## ***Recommendations***

Native Tree and Shrub Planting

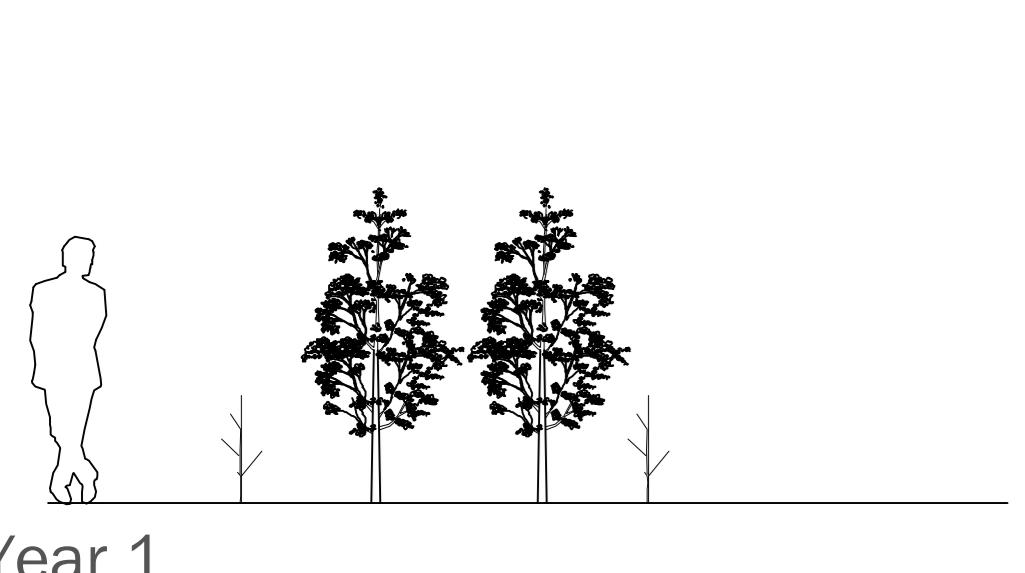
***9 - Whether the bunds will be softened to appear ‘natural’ (the bunds shown on the detailed landscape proposals in Appendix 9.4 look very ‘angular’).***

The landscape proposals have been based on detailed levels provided by engineers. The level of the bunds has been landscape-led, limiting the profile of the bunds to no steeper than 1 in 3 in order to reduce the likelihood of there being an engineered appearance. Each bund has been planted with native trees and shrubs that reflect the local context throughout the scheme to maintain a buffer to the wider setting.
